OFFICIAL NOTICE OF DECISION

CITY OF ALBUQUERQUE
PLANNING DEPARTMENT
DEVELOPMENT REVIEW BOARD

Project# 1001816

12DRB-70170 VACATION OF PUBLIC SIDEWALK EASEMENT

The purpose of this plat is to consolidate Lots 10-12 and vacated right-of-way into one (1) lot and to grant the easements as shown hereon.

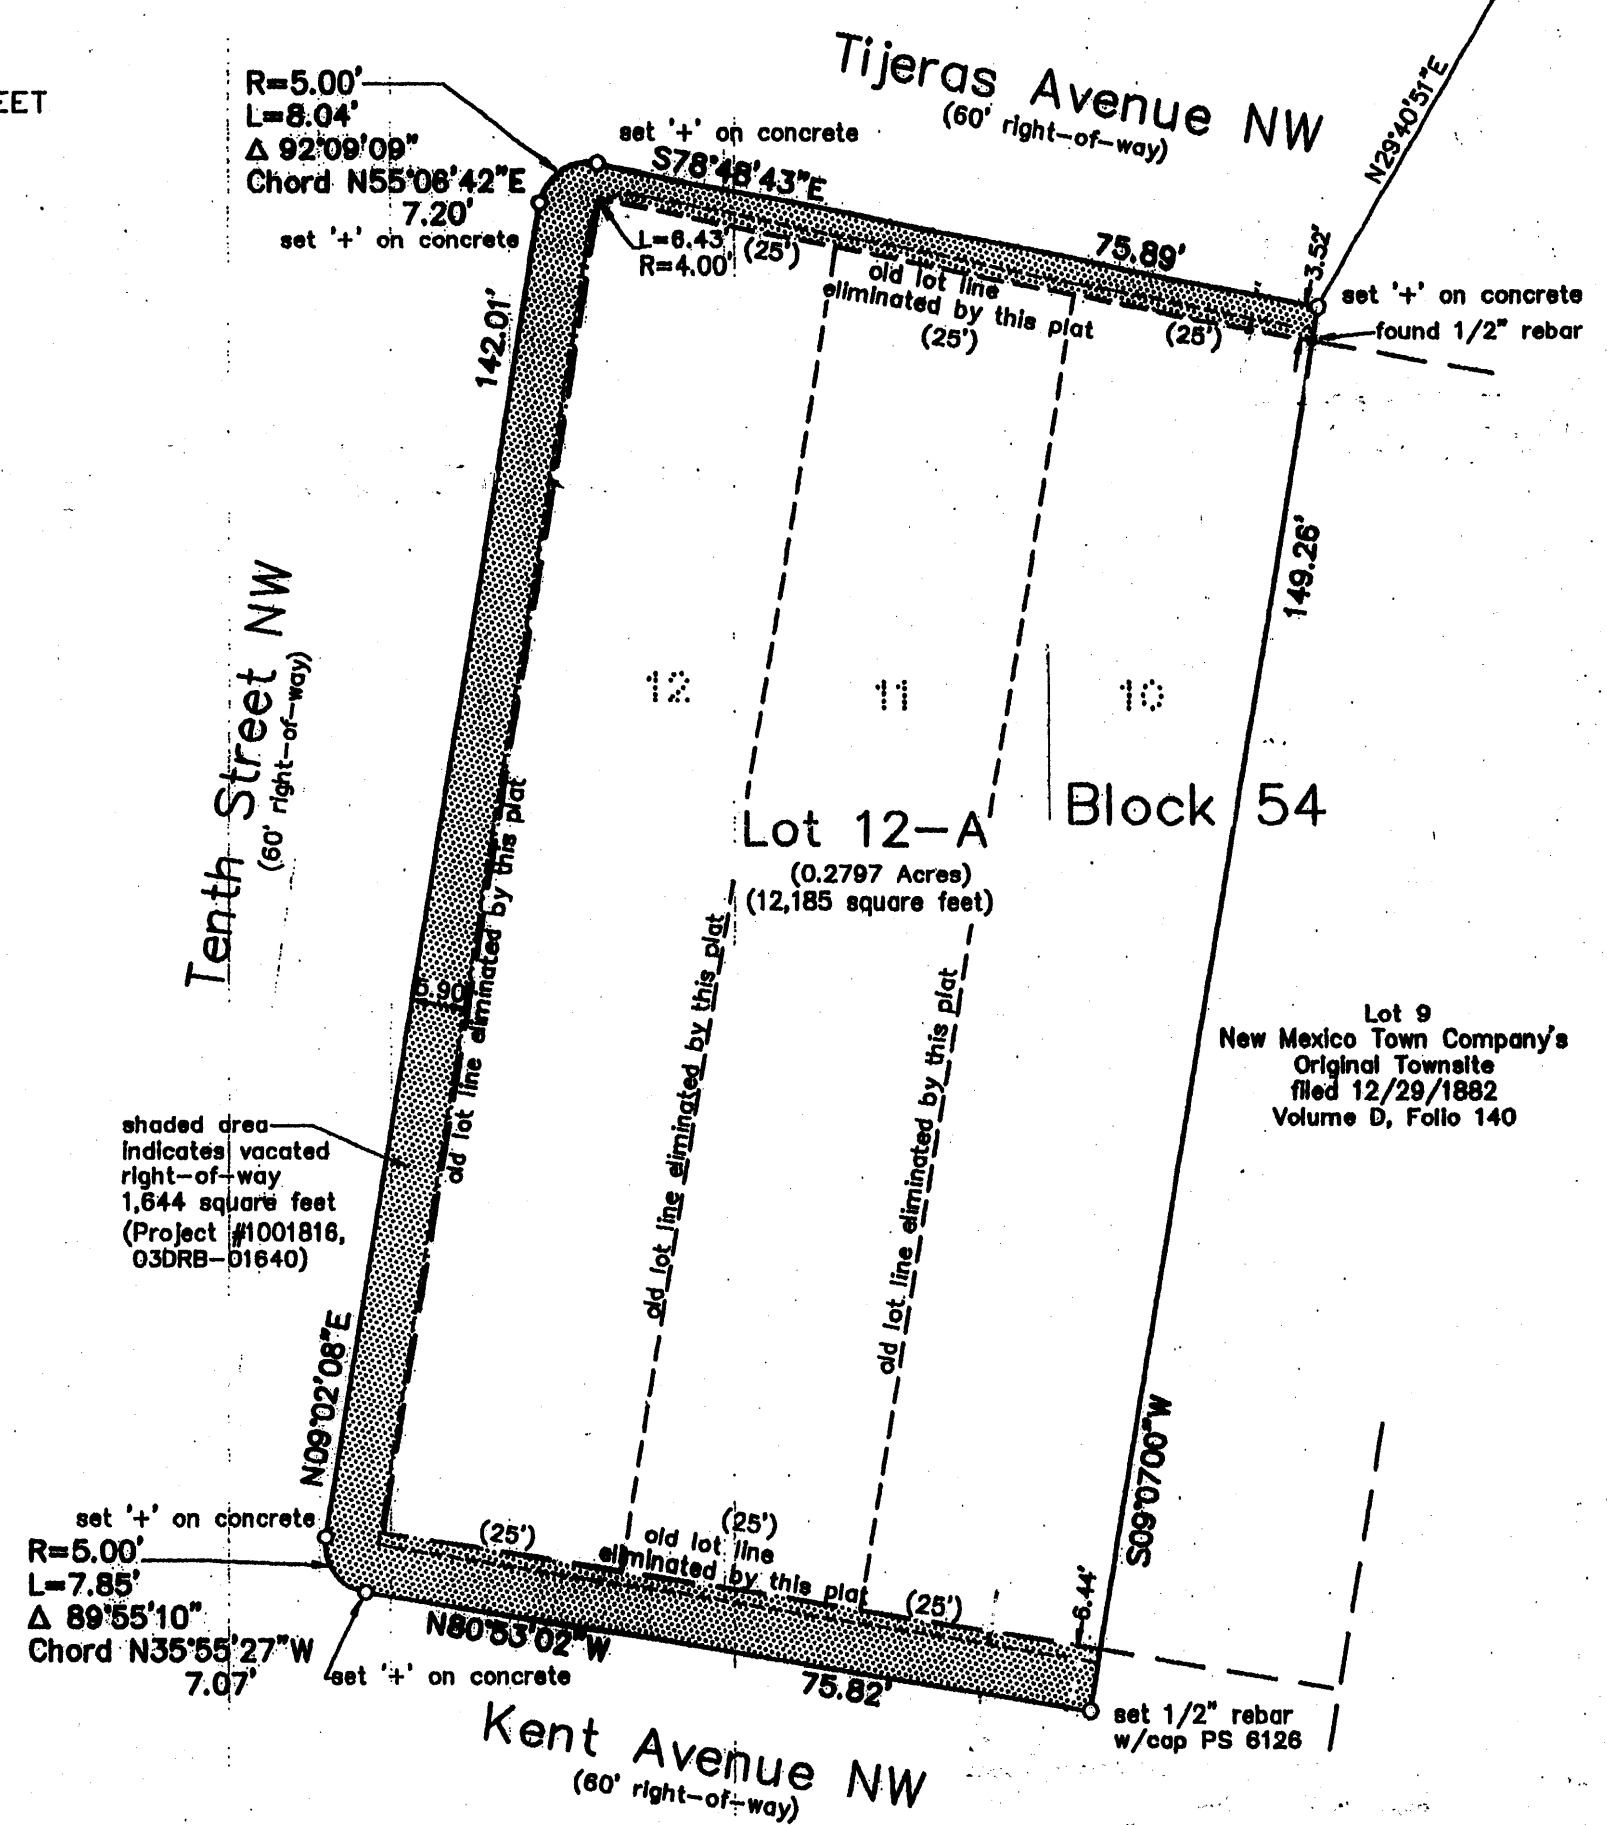
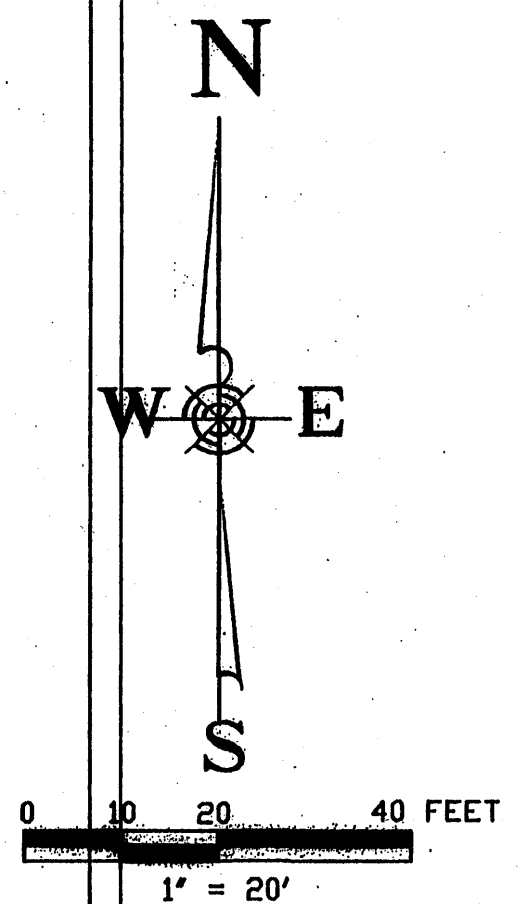
2. The public welfare is in no way served by retaining the easement along Kent Avenue NW or 10th Street NW because the City of Albuquerque does not anticipate any need to utilize the existing easement for sidewalk purposes, based on the submission by the applicant and existing conditions. However, the easement along Tijeras Avenue NW is used for an existing sidewalk, and the sidewalk is uniform for this block and the block to the west. Transportation Objective 1.2 of the Downtown Neighborhood Sector Development Plan is to maintain the width and location of existing parkways and sidewalks, therefore the public welfare would be served by retaining this easement.

An exhibit without extraneous spot elevation data is needed to clearly show curb, gutter and sidewalk with property line and easement. It appears the public sidewalk on Tijeras is within the platted easement. Refer to comments from affected agencies/ Transportation Development plus any public hearing comments regarding proposed extension.

At the August 15, 2012 Development Review Board meeting, the vacation of the Public Sidewalk Easements along Kent Avenue NW and 10th Street NW were approved as shown on Exhibit B in the Planning file per section 14-14-7-2(A)(1) and (B) (1)(3) of the Subdivision Ordinance. The vacation of the Public Sidewalk Easement along Tijeras Avenue NW was denied.
